REQUEST

Current Zoning: N1-A (Neighborhood 1)
Proposed Zoning: N2-A(CD) (Neighborhood 2-A, Conditional)

The petition proposes to develop a south Charlotte site occupied by one single family dwelling with a community of 110 multifamily attached dwellings.

Delray at Providence Road West, LLC

**SCHEMATIC
SITE PLAN**

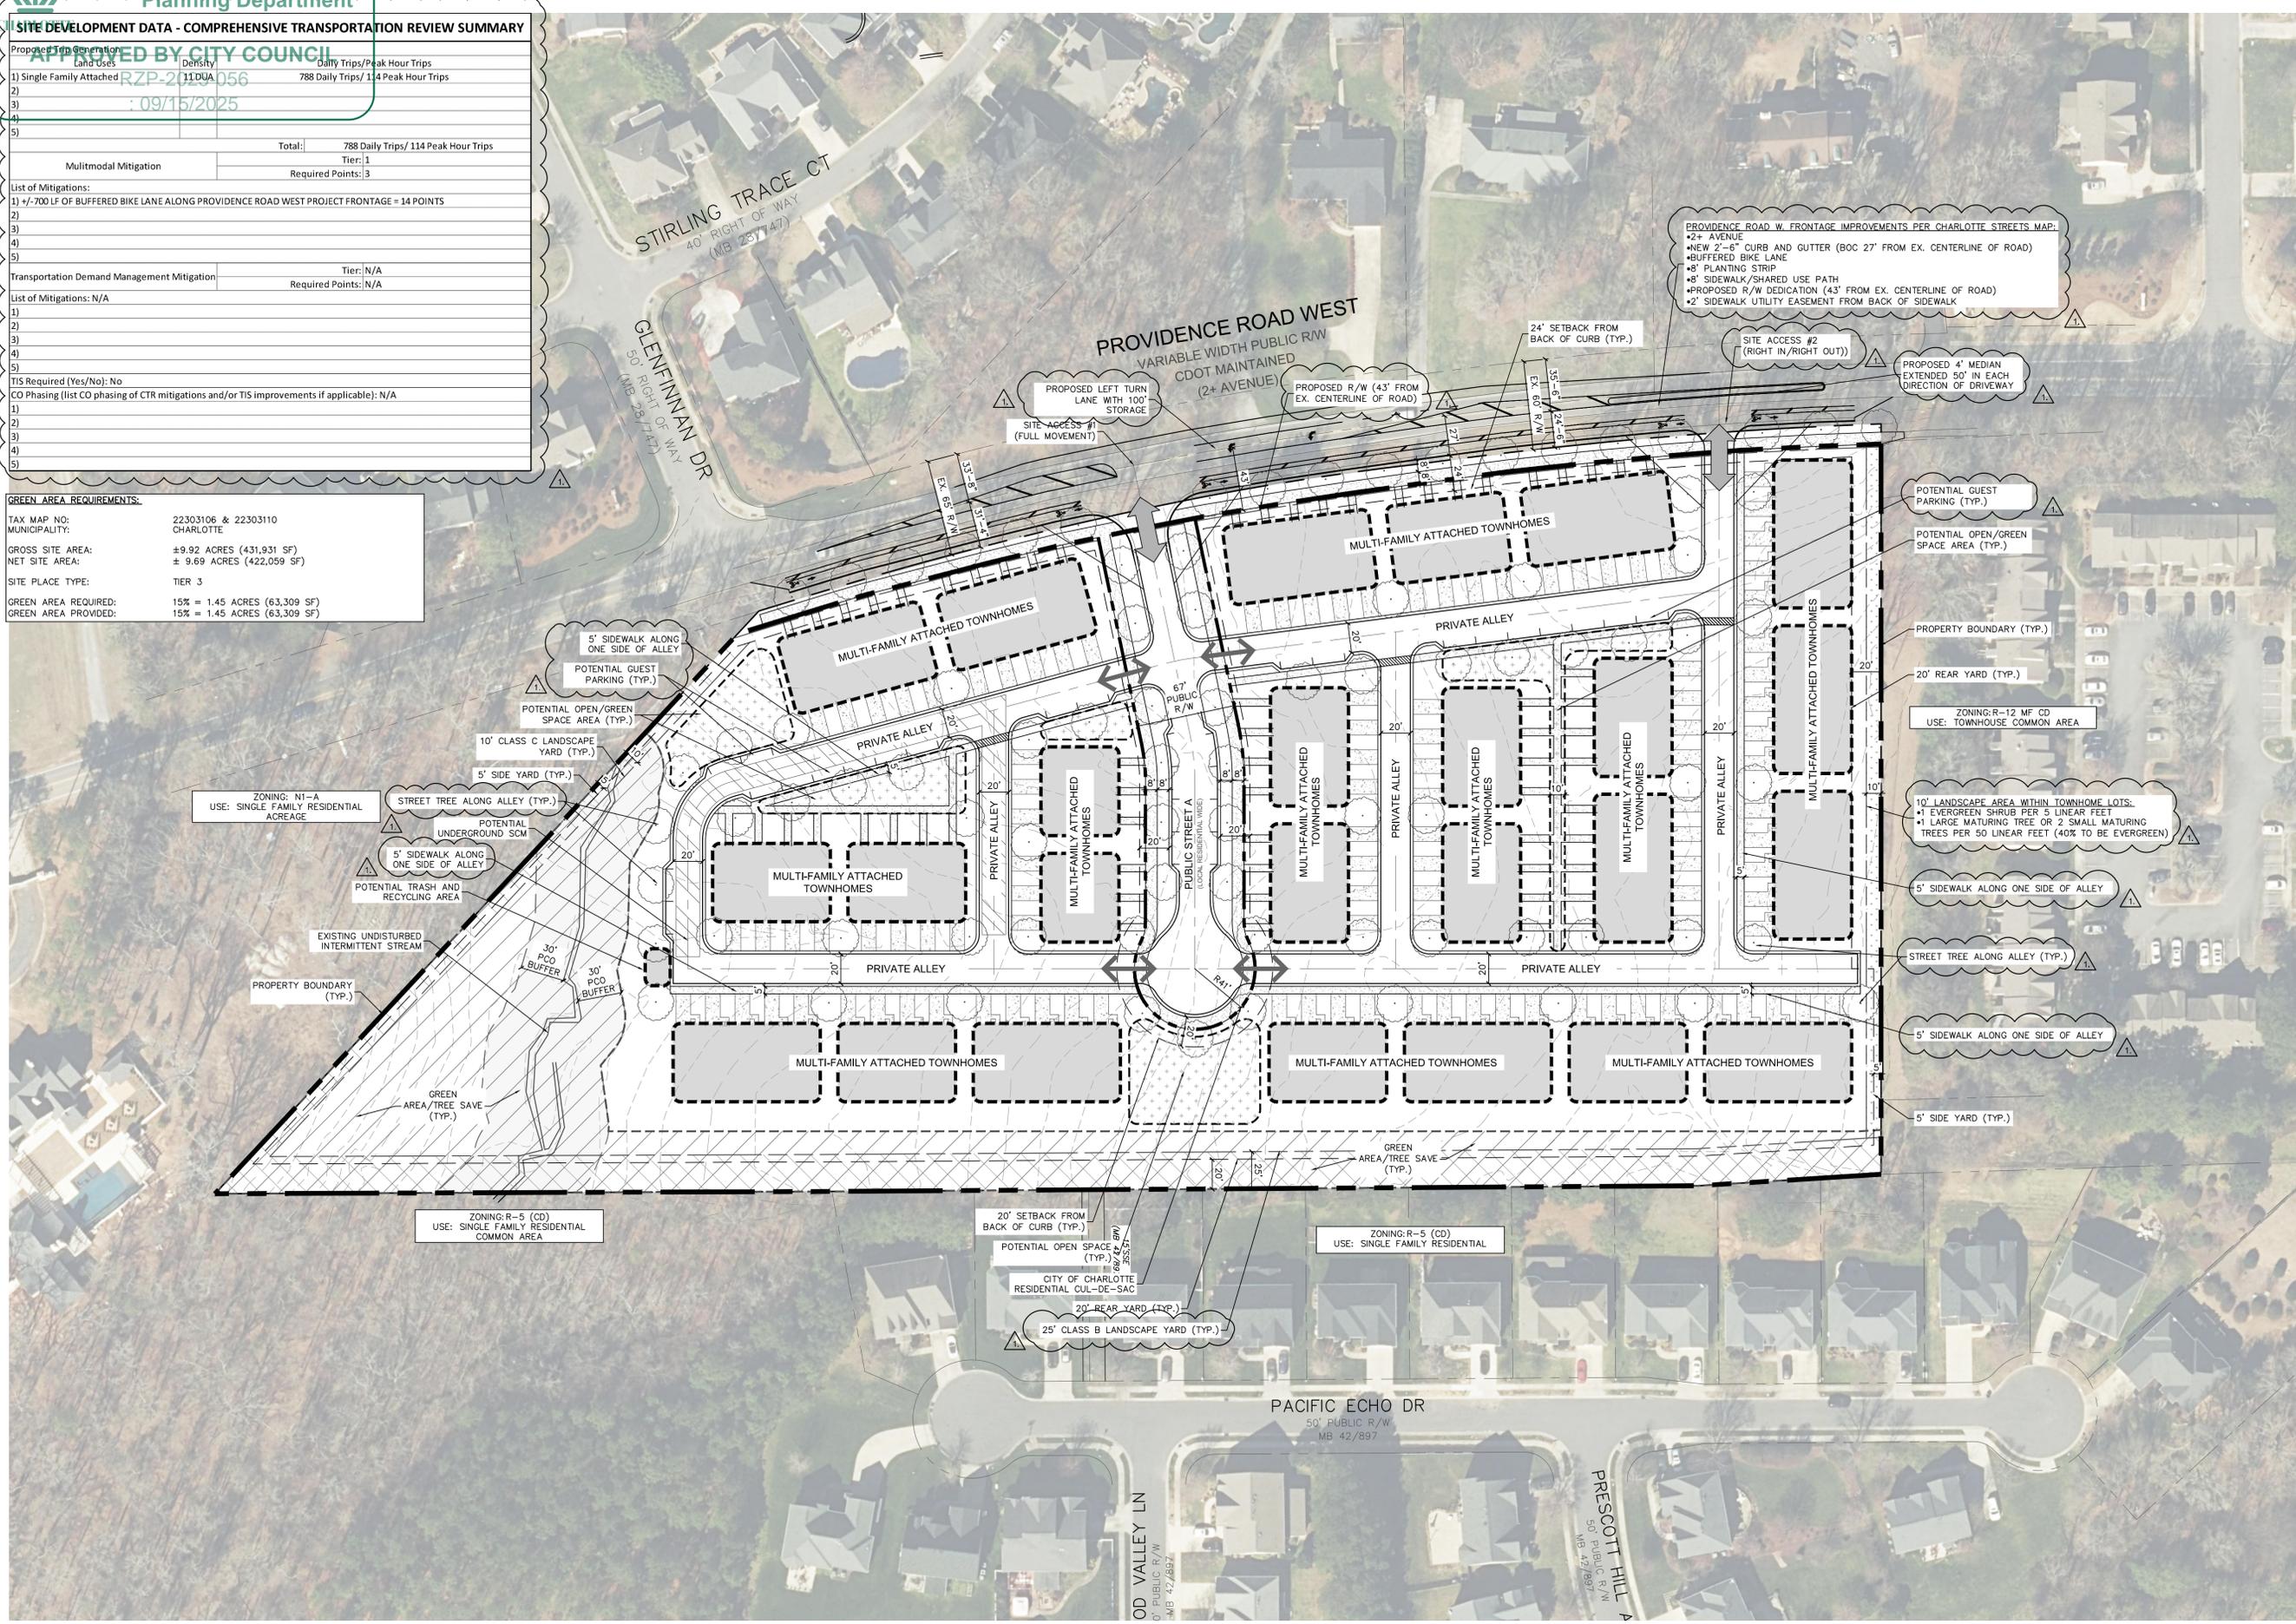
1. Add a 6' tall opaque fence to the 25' Class B landscape yard along the southern property boundary. Add fence to Note III.a and label on site plan. **OUTSTANDING**
2. ~~Revise note III.d.5 to commit to a minimum dimension of 50' or more measured in all directions.~~ **ADDRESSED**
3. ~~Add a conditional note committing to a 10' Class C landscape yard along the western property boundary, as is shown on the site plan.~~ **ADDRESSED**
4. ~~Revise note III.d.1 to quantify proposed enhanced plantings.~~ **ADDRESSED**
